OUT18/9746

Ms Jessie Evans  
Resource Assessments  
NSW Department of Planning and Environment

**Dendrobium Coal Mine Modification 8 – Surface Supply Upgrade (DA 60-03-2001 Mod 8)  
Comment on the Environmental Assessment**

Figure 1- Proposed Dendrobium Surface Kiosk Supply

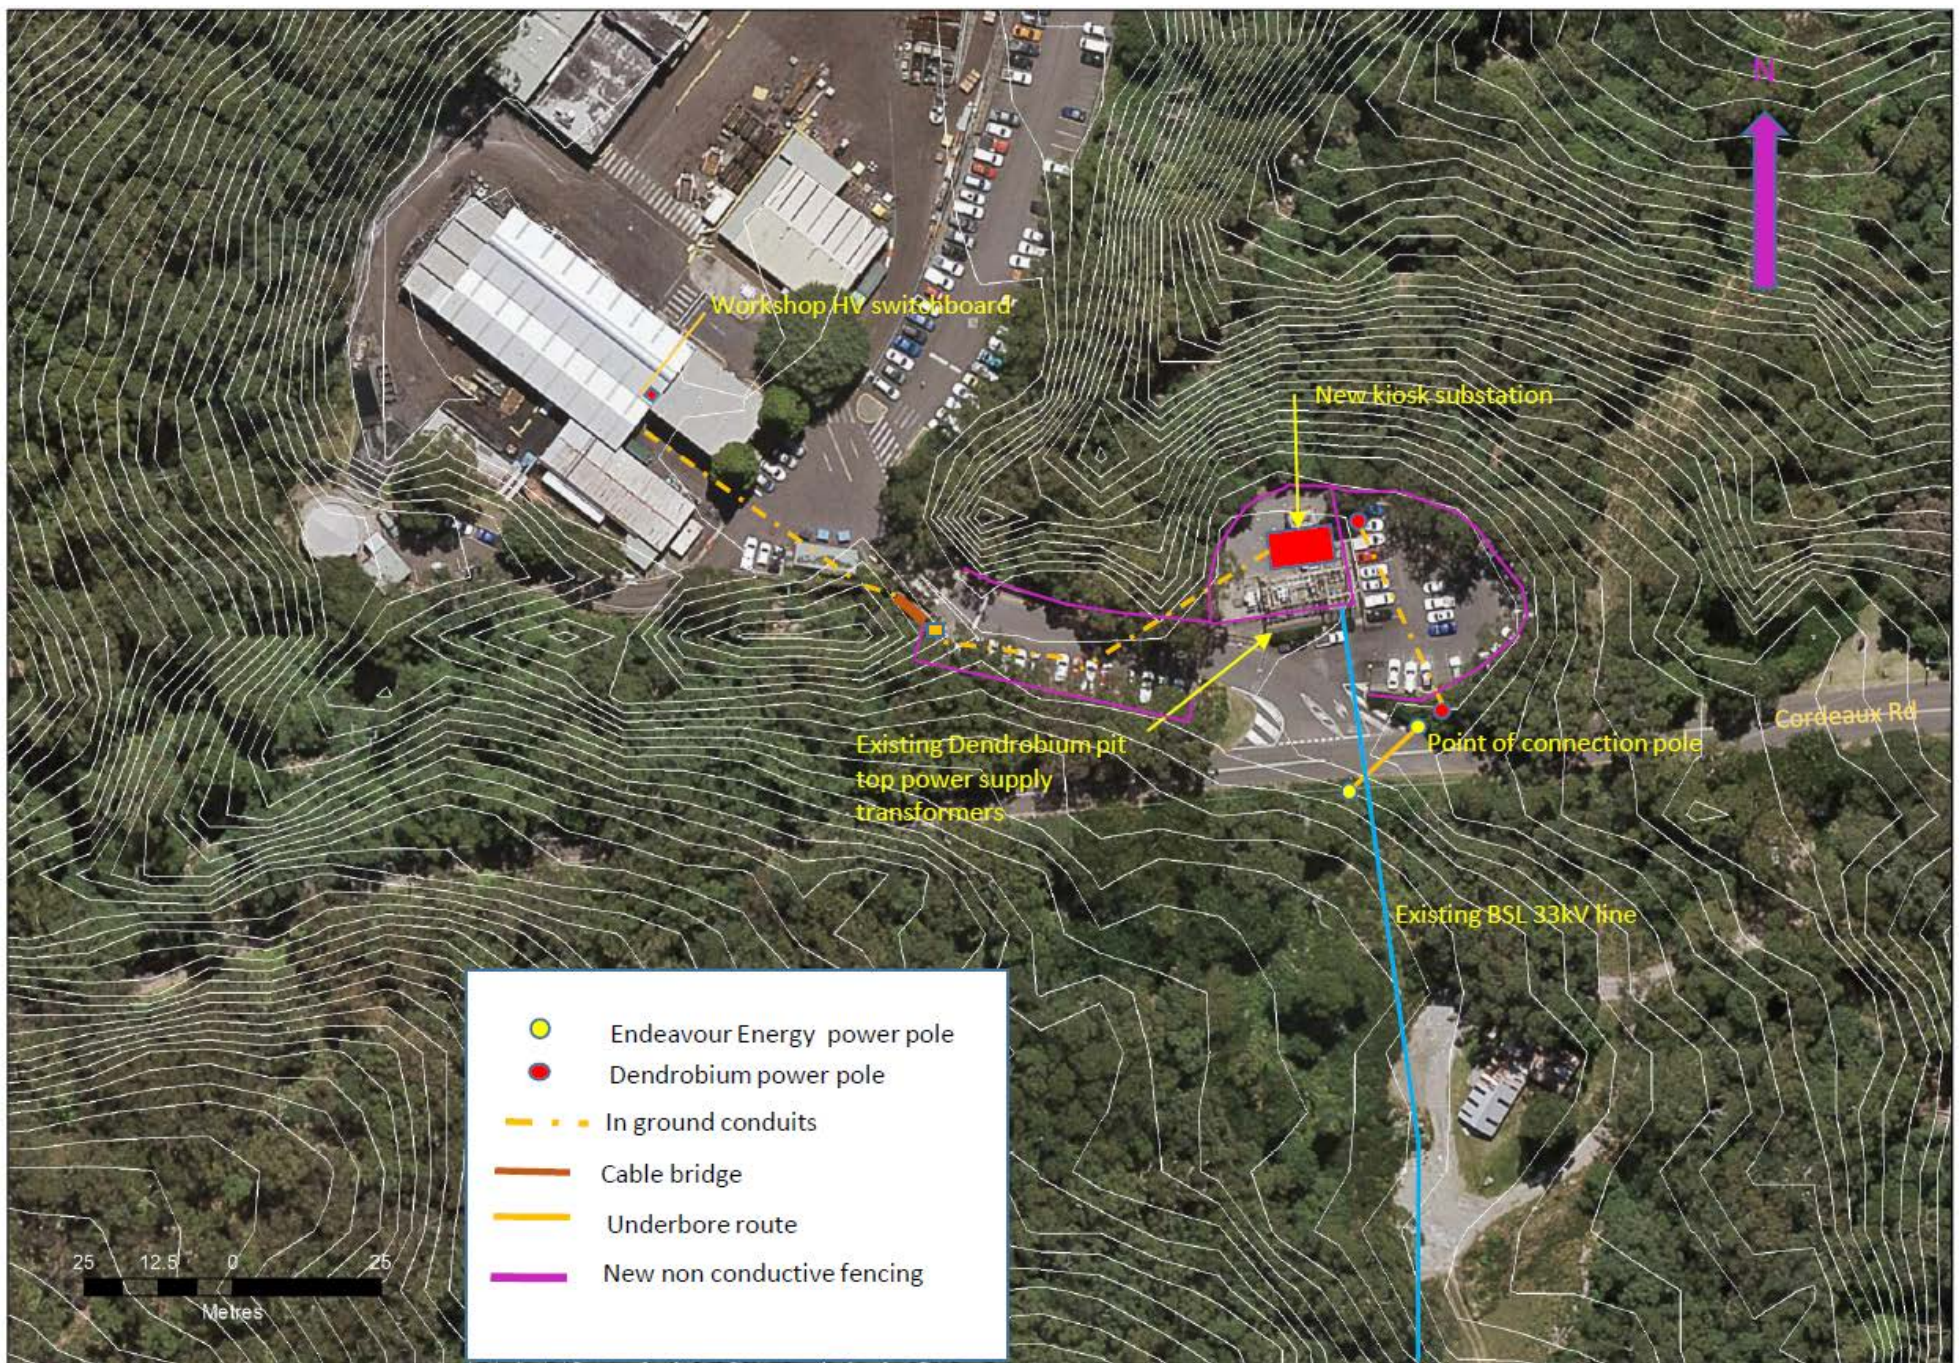
Works within waterfront land (i.e. 40 m of the high bank of the American Creek) should be undertaken in accordance with the [Guidelines for Controlled Activities on Waterfront Land](#) (DPI 2012). This includes managing sediment and erosion control during construction until the site is stabilised, reinstatement of the ground level, stabilisation via revegetation, and mitigating runoff and disturbance impacts to American Creek. If works are required within the bed and banks of American Creek further consultation with the Department of Industry Lands and Water is requested.

- A Construction Environmental Management Plan is to be developed in consultation with DoI Lands & Water prior to commencement of construction.
- Works within waterfront land are to be in accordance with the Guidelines for Controlled Activities on Waterfront Land (DPI 2012).
